MECKLENBURG COUNTY
Park and Recreation Department

MEMORANDUM

RE: Rezoning Petition # 2008-116 Intersection of Harding Place and Greenwood Cliff

Sheet Description #  
**REZONING PLAN**

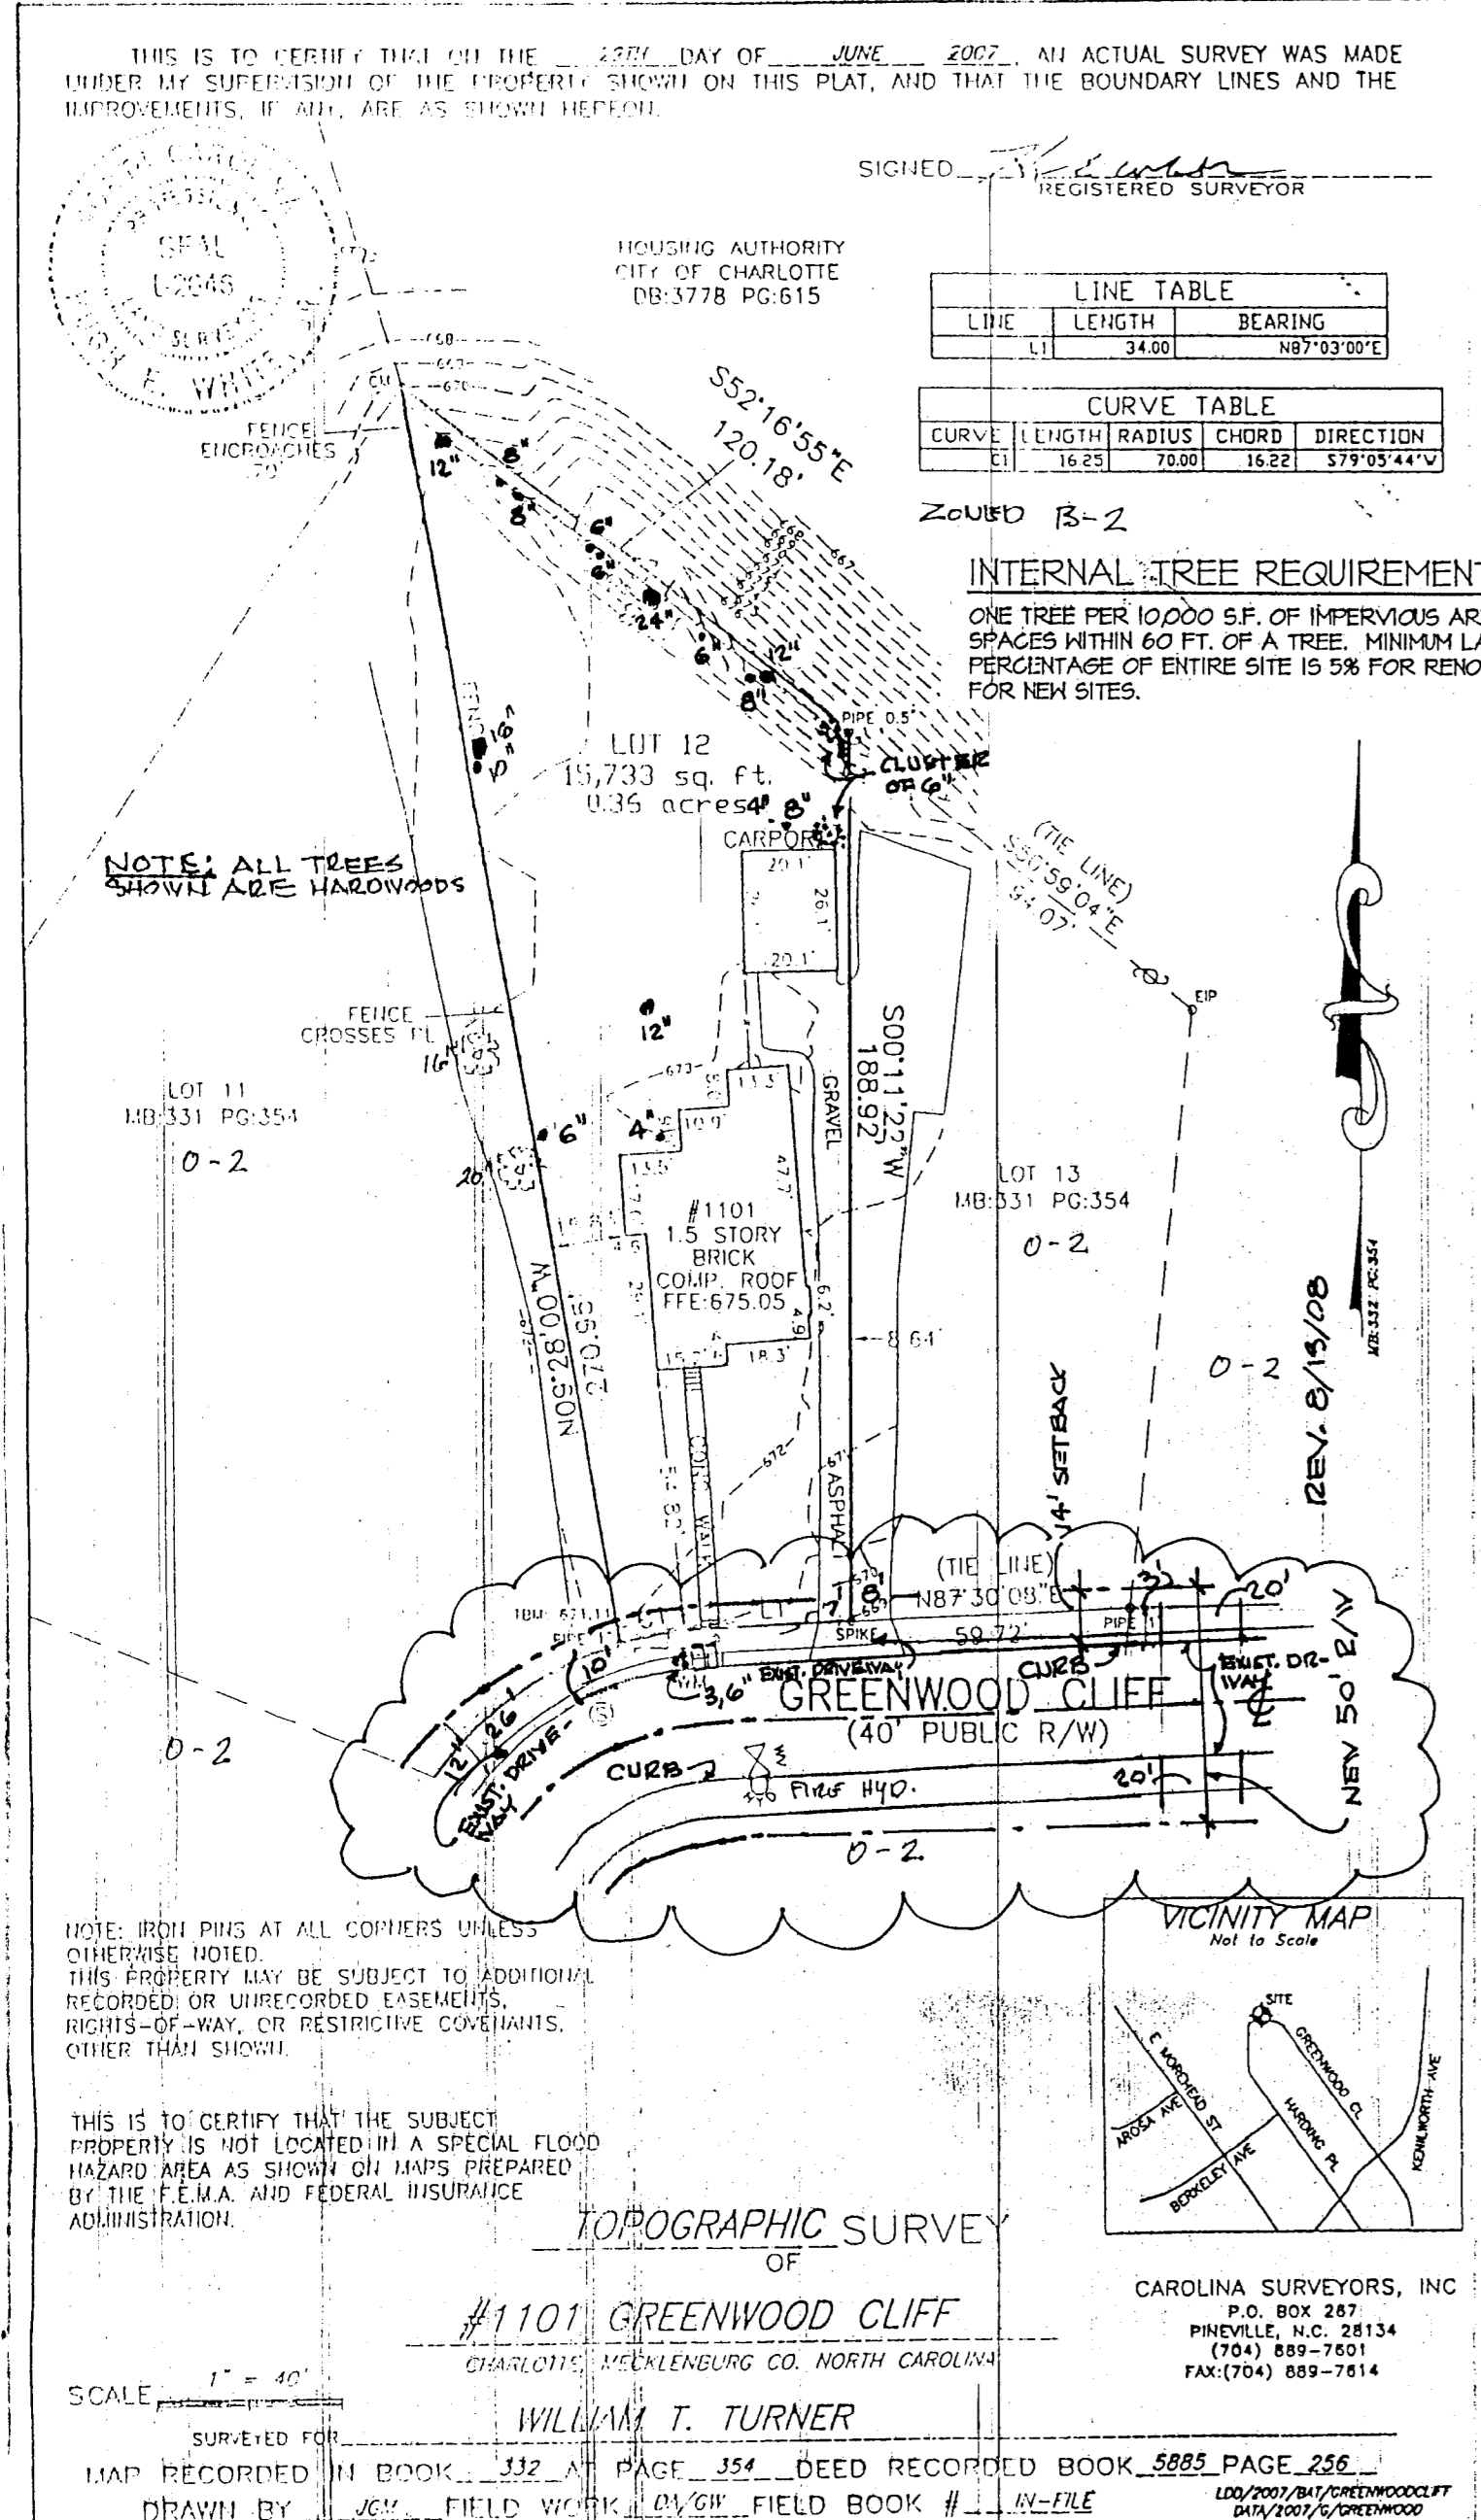
Mecklenburg County Park and Recreation requests a pedestrian connection from Harding Place to the rear of the property to allow access to Baxter Street Park. We request the connection be a minimum ten foot wide sidewalk open and accessible to the public at all times. MCPR will work the Charlotte Housing Authority to continue the pedestrian connection directly into the park.
